V5_Drainage letter_comments.pdf Markup Summary

**FINAL DRAINAGE REPORT
LOT 2, BENT GRASS EAST COMMERCIAL FILING NO. 4
CARUBIA PROPERTIES**

PCD FILE NO. PPR256

DATE: JUNE 19, 2025
SCALE: AS INDICATED
DRAWN BY: JWD
CHECKED BY: JWD
PROJECT NUMBER: 2024-019
SHEET: C5.13
U/A - RPA EXHIBIT

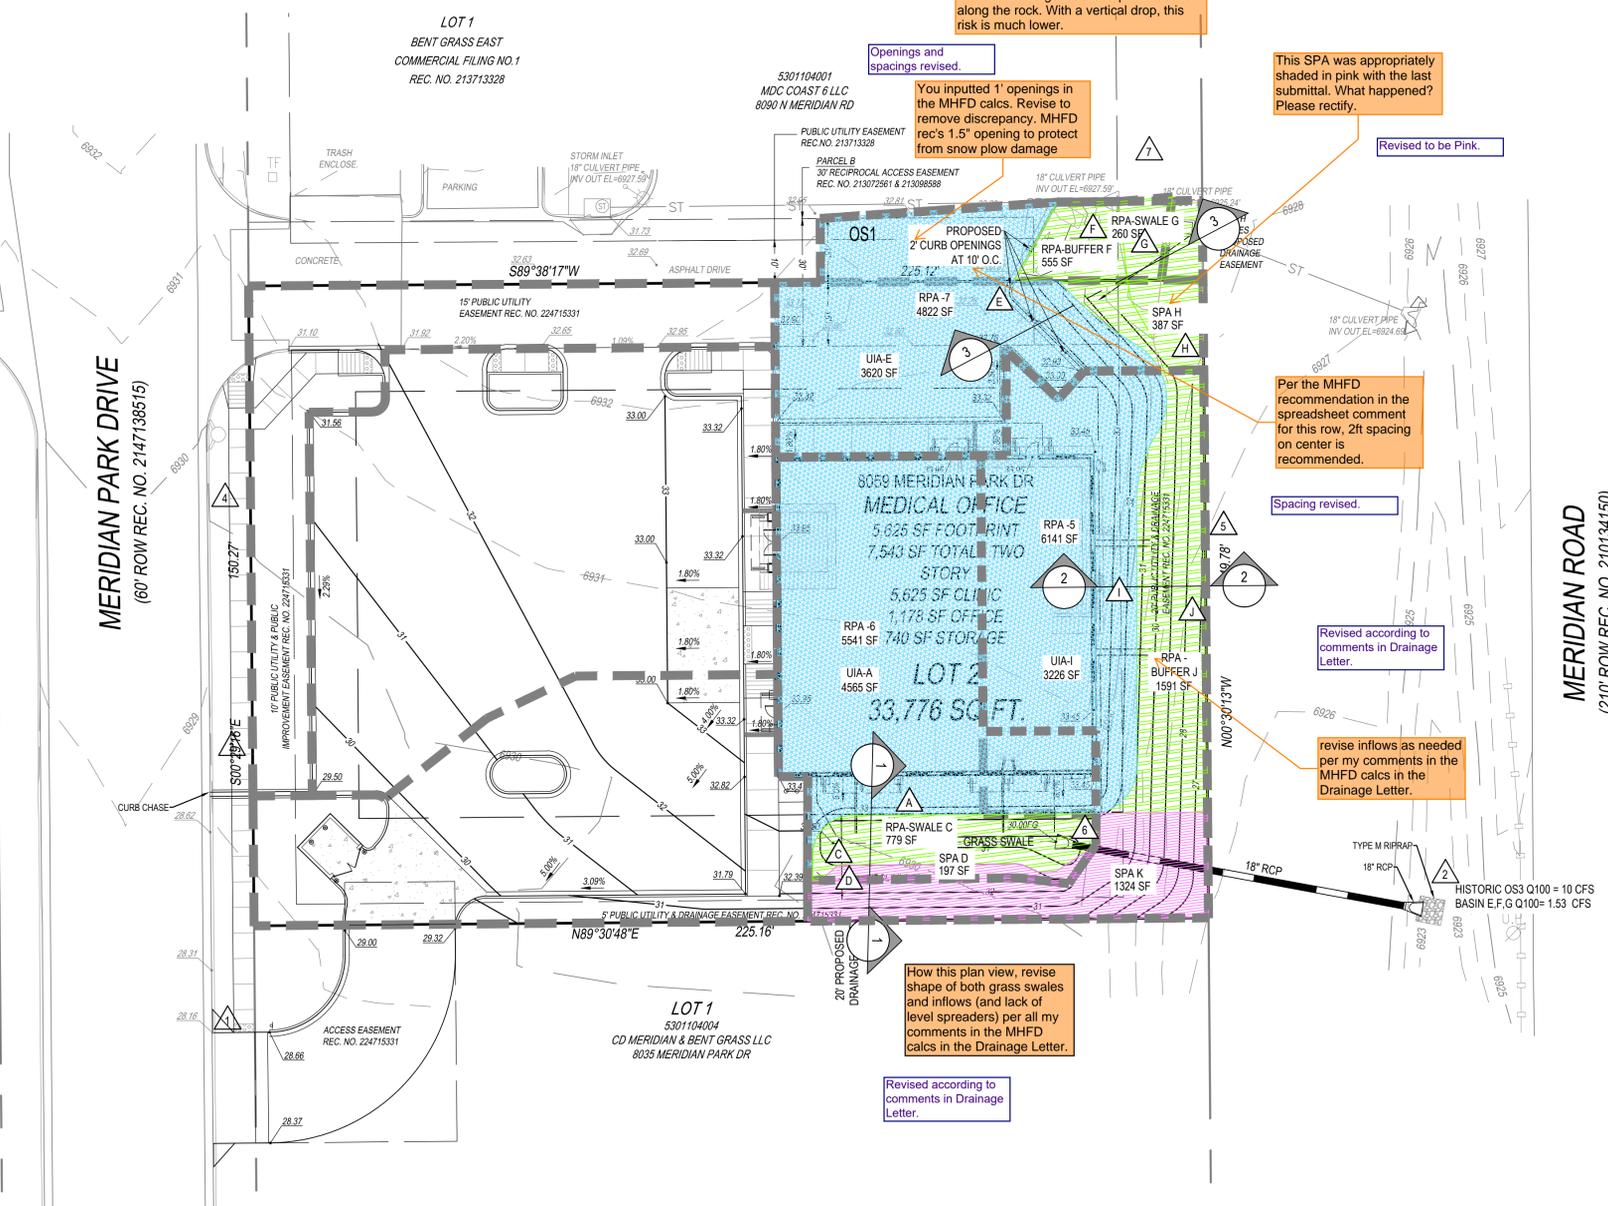
Unfortunately this reduction is now 56.7%, which is below the min 60%...

Based on the LxW provided on the next page, the RPA is only 530sqft. This discrepancy is due to MHFD's notes on that row of the spreadsheet: only the bottom area of the swale counts towards the RPA, not the side slopes. And the section of this swale shown on the CDs shows that there is not a bottom since it is a v-shaped swale. MHFD guidance states that RPA swales must be trapezoidal shaped.

Based on the LxW provided on the next page, the RPA is only 180sqft. This discrepancy is due to MHFD's notes on that row of the spreadsheet: only the bottom area of the swale counts towards the RPA, not the side slopes. And the section of this swale shown on the CDs shows that there is not a bottom since it is a v-shaped swale. MHFD guidance states that RPA swales must be trapezoidal shaped.

## SECTION 2

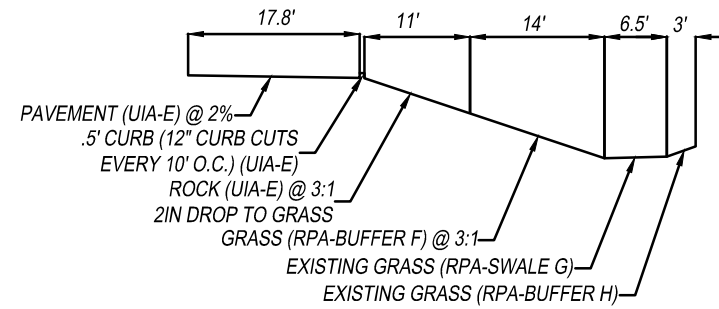
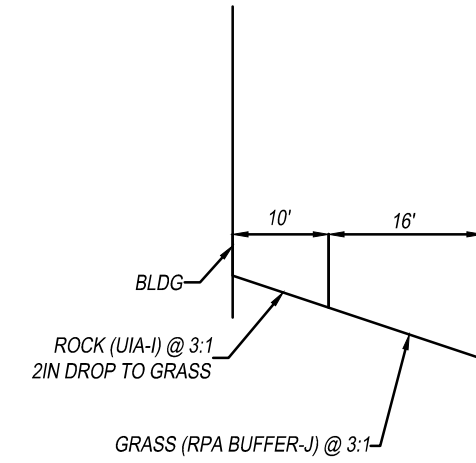
Where is this vertical drop? The end of the roof drains are going to be 3in above the RPA? Provide a detail showing this in the CDs. Section 2 in the CDs currently only shows a 2in drop from edge of building (not pipe) but it's via a sloped rock area, which doesnt work per my comment in the CDs.

PROPOSED  
DRAINAGE PLAN

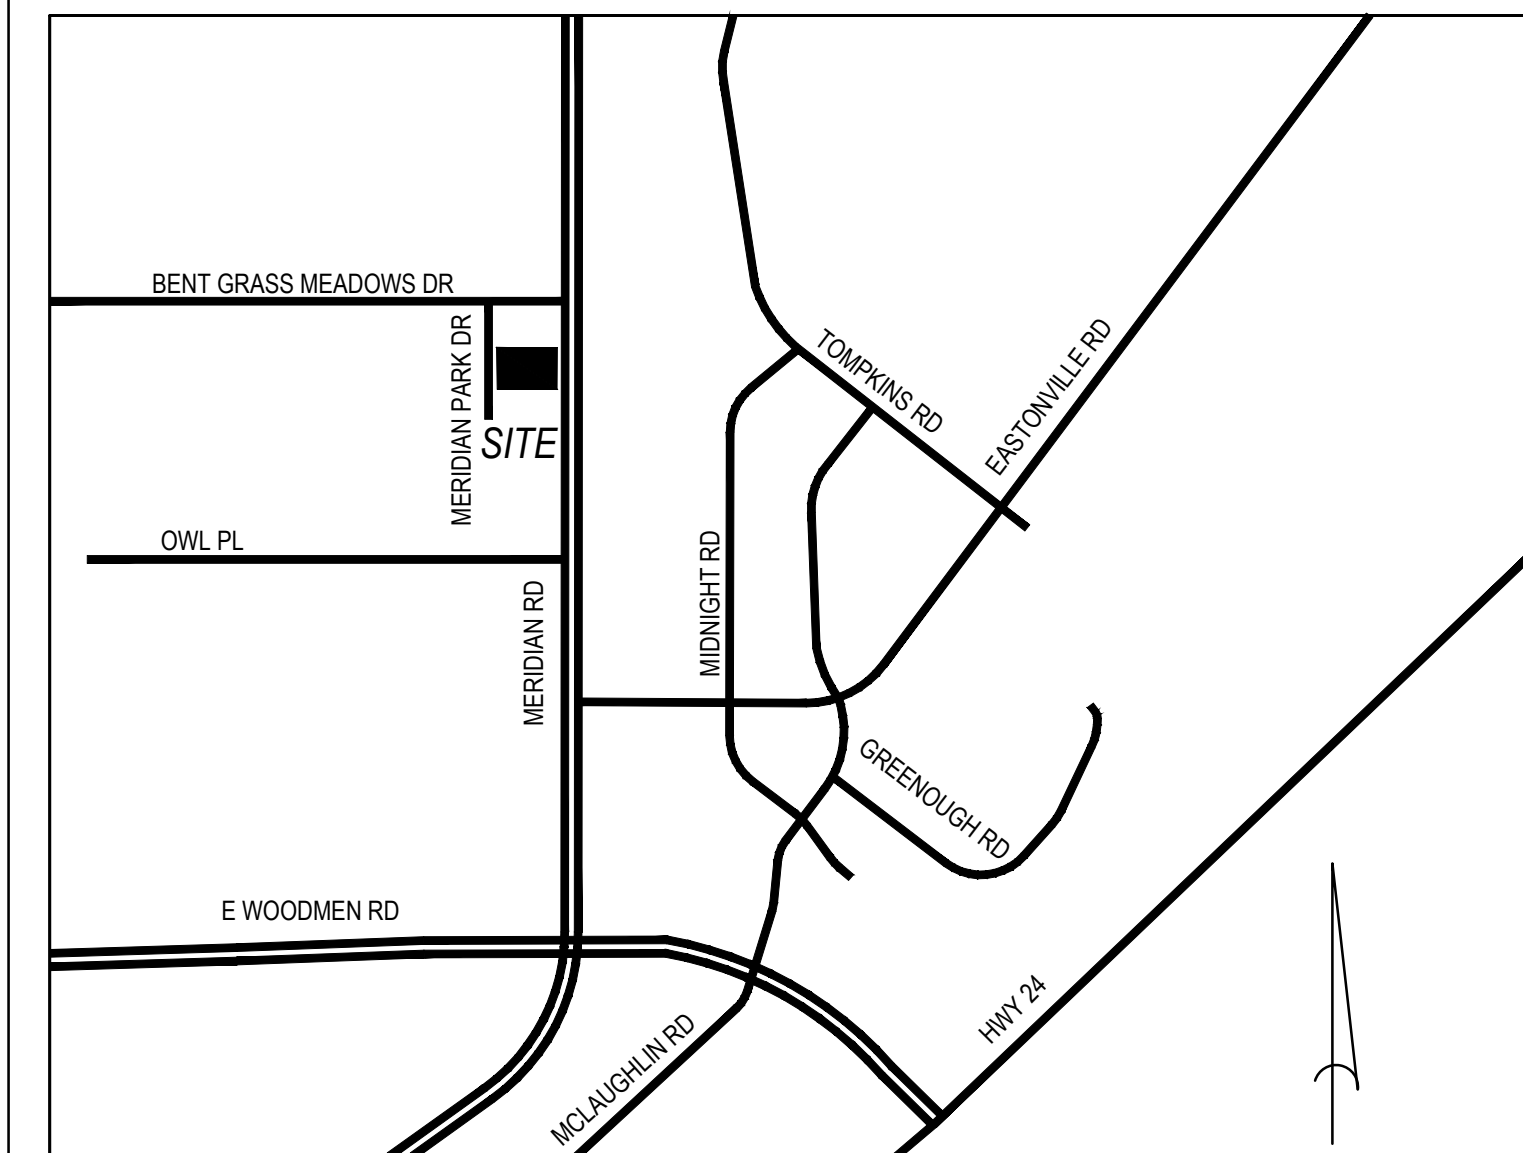
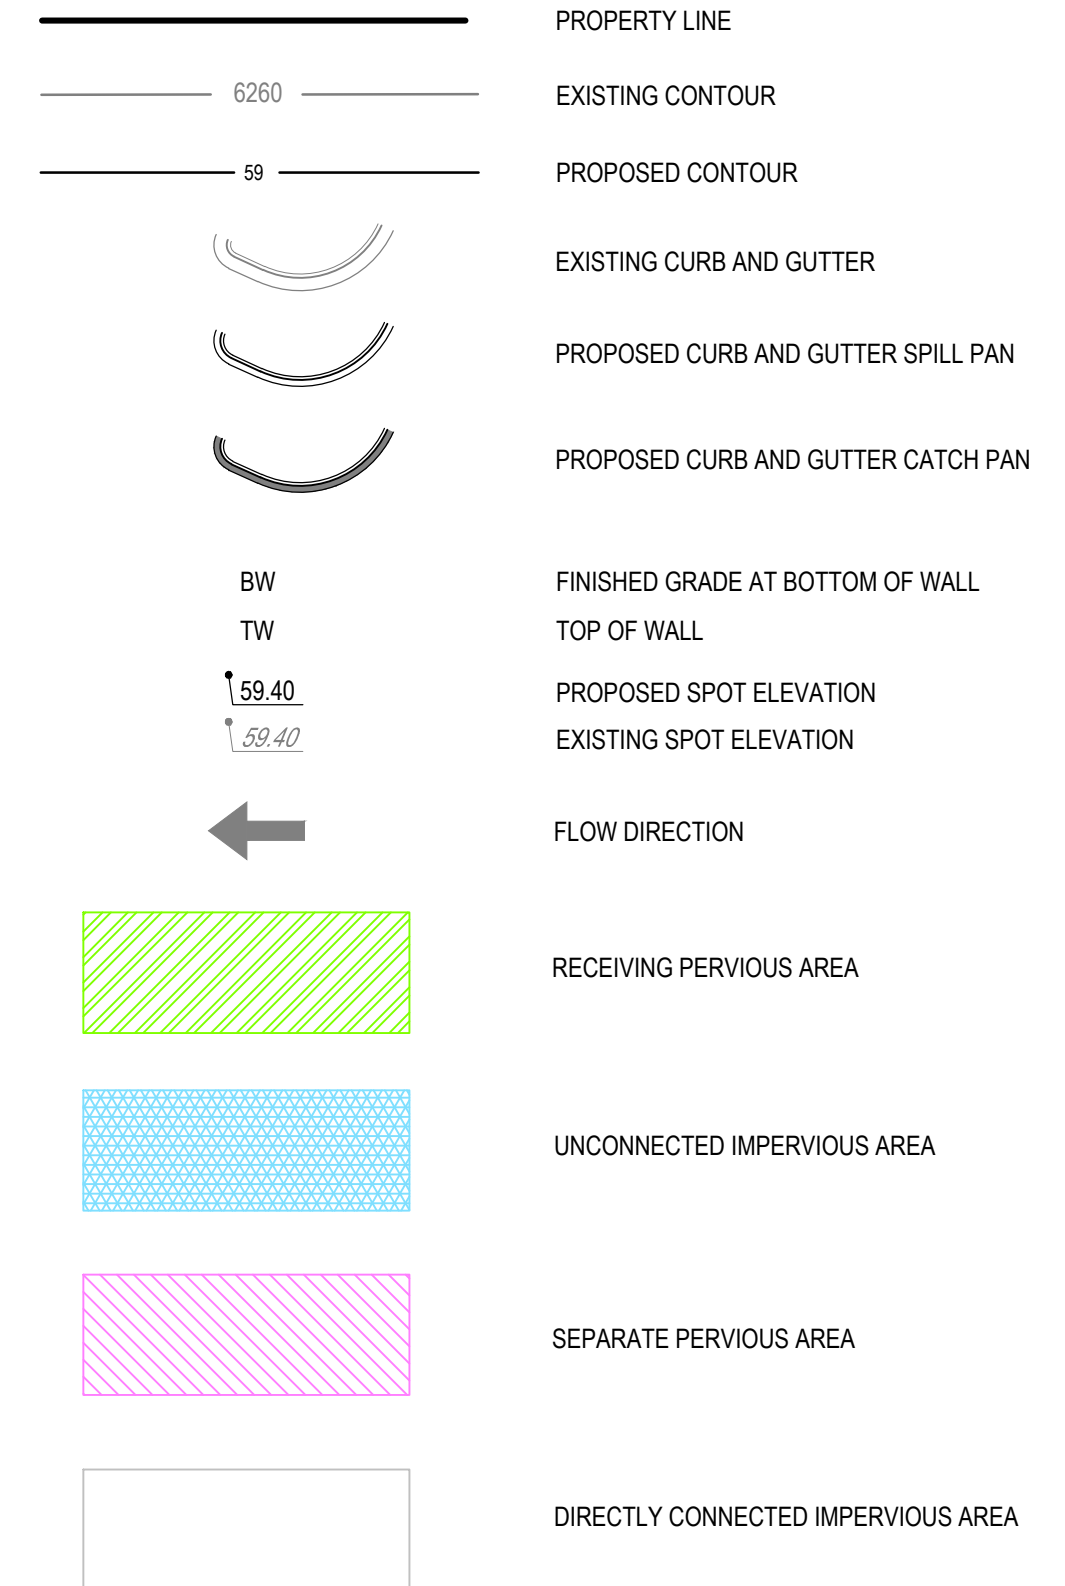
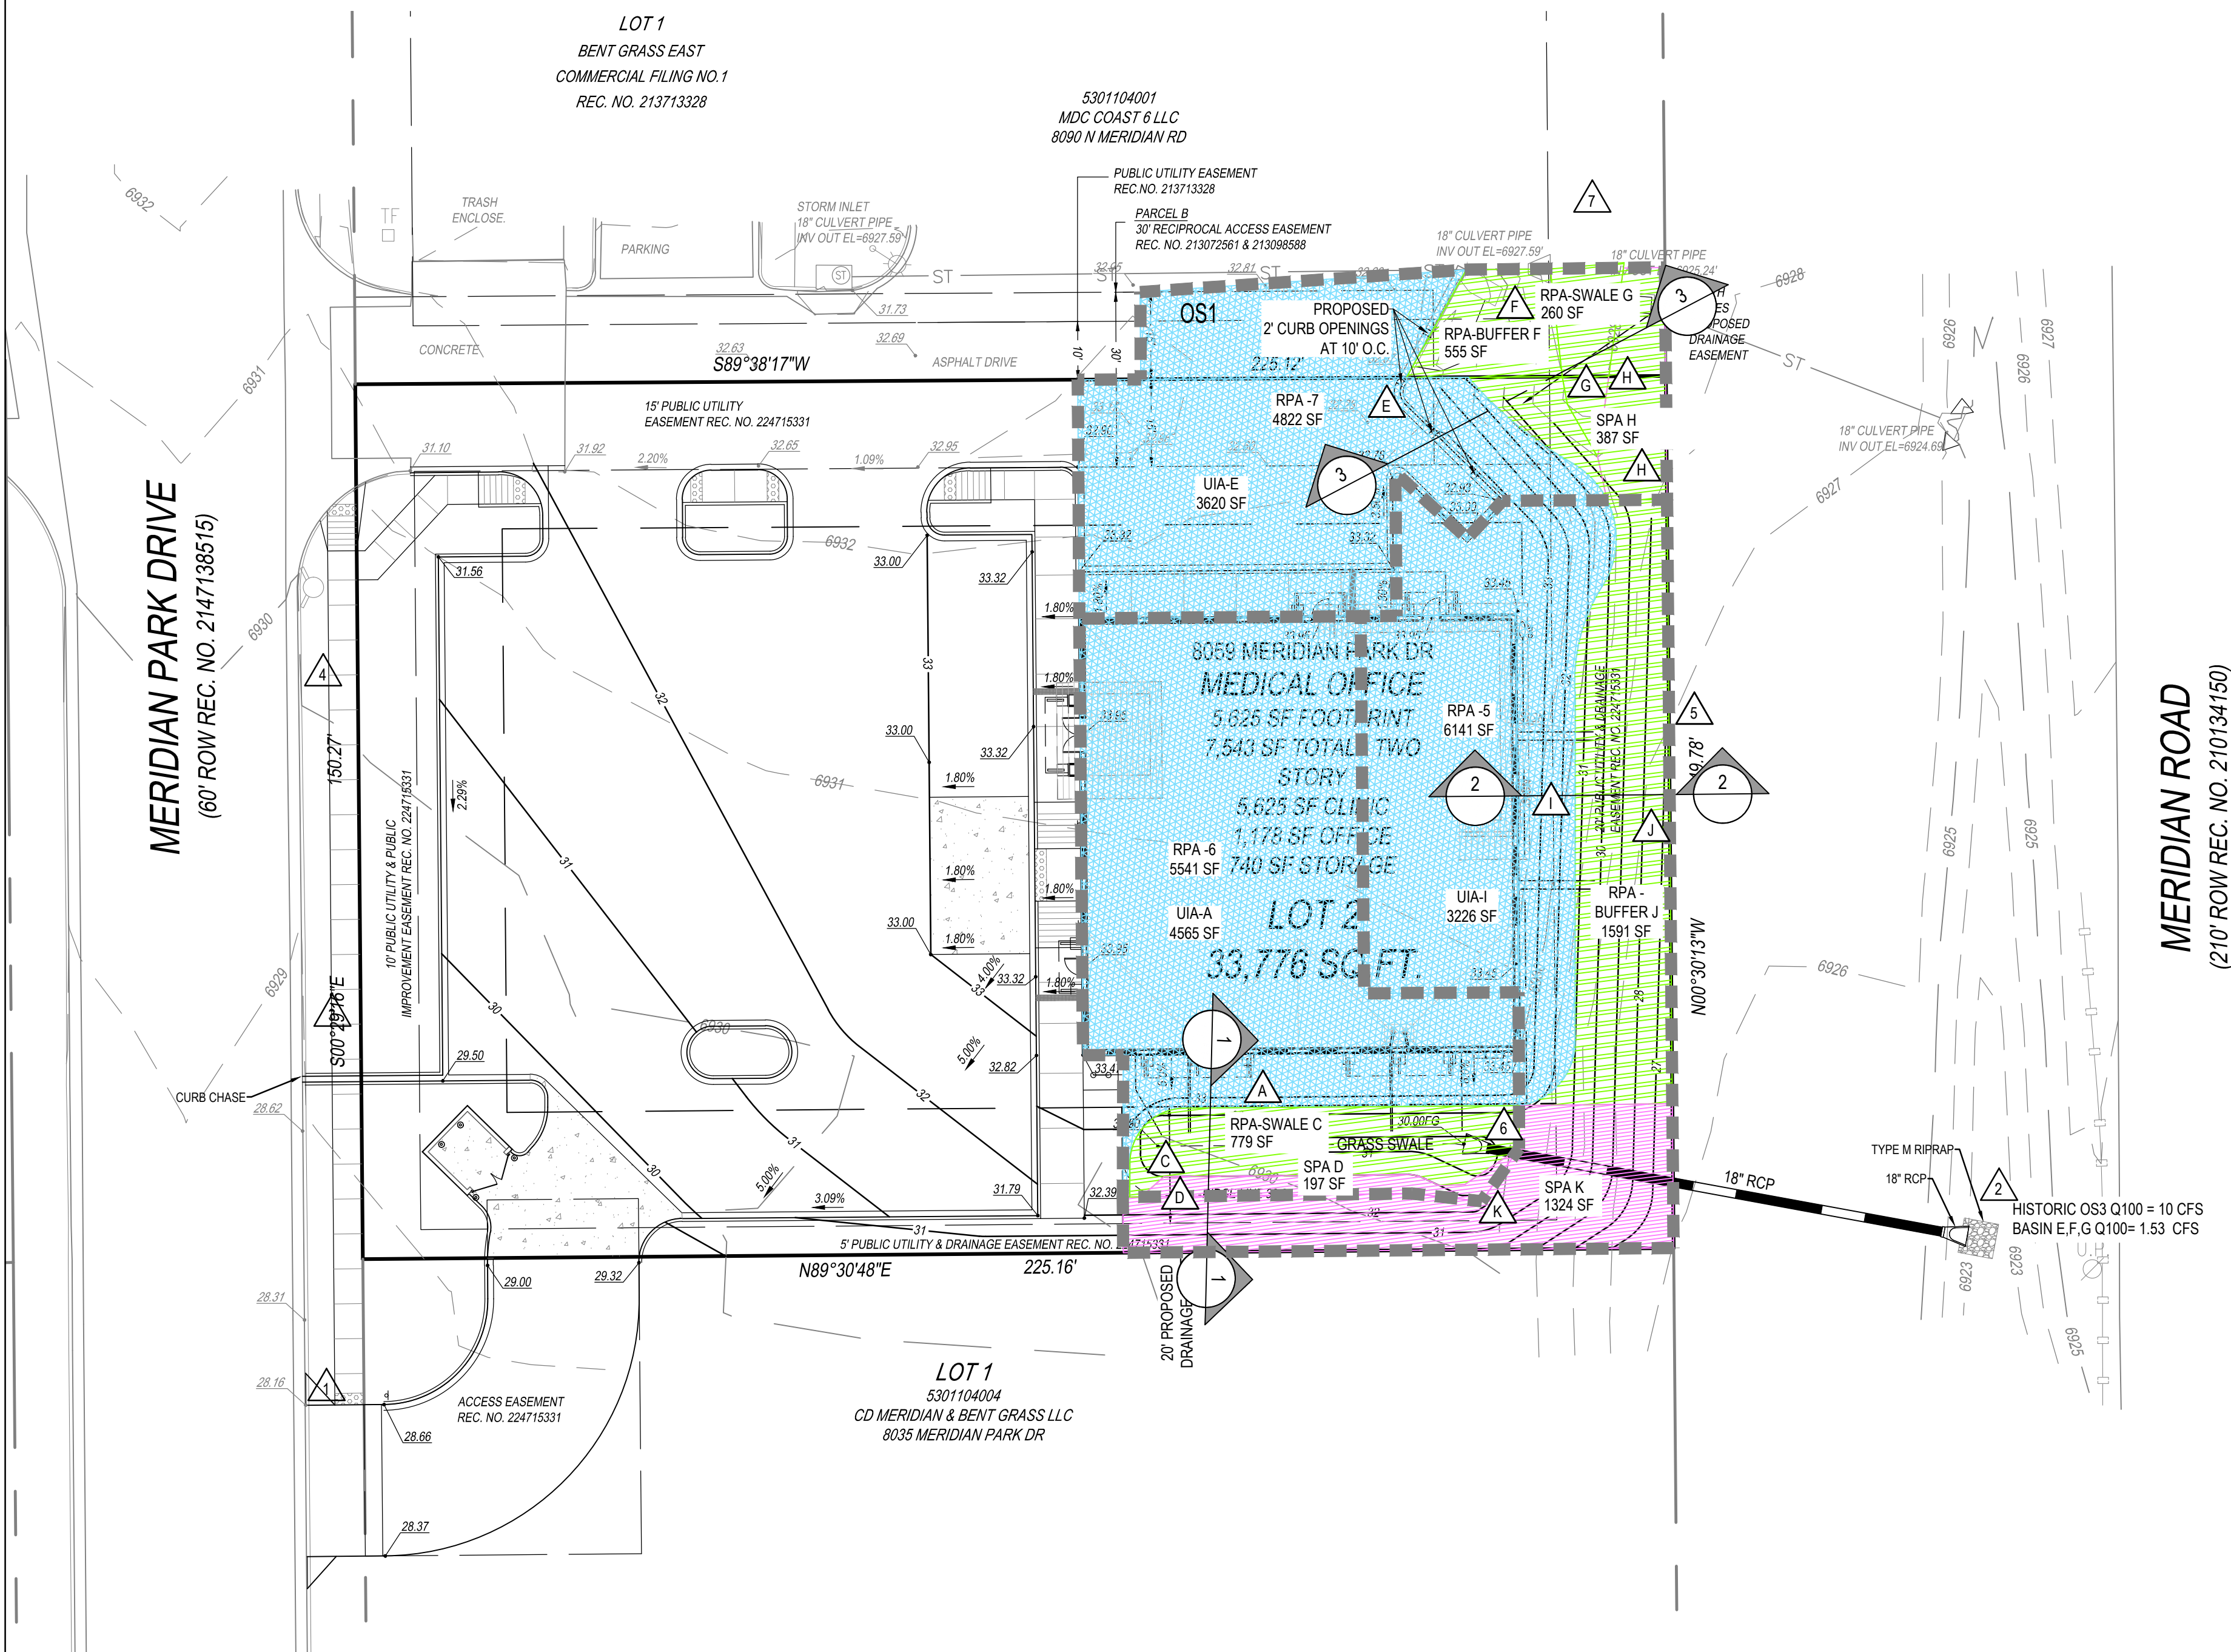
Please update this sheet per all of my comments in the duplicate sheet in the CDs.
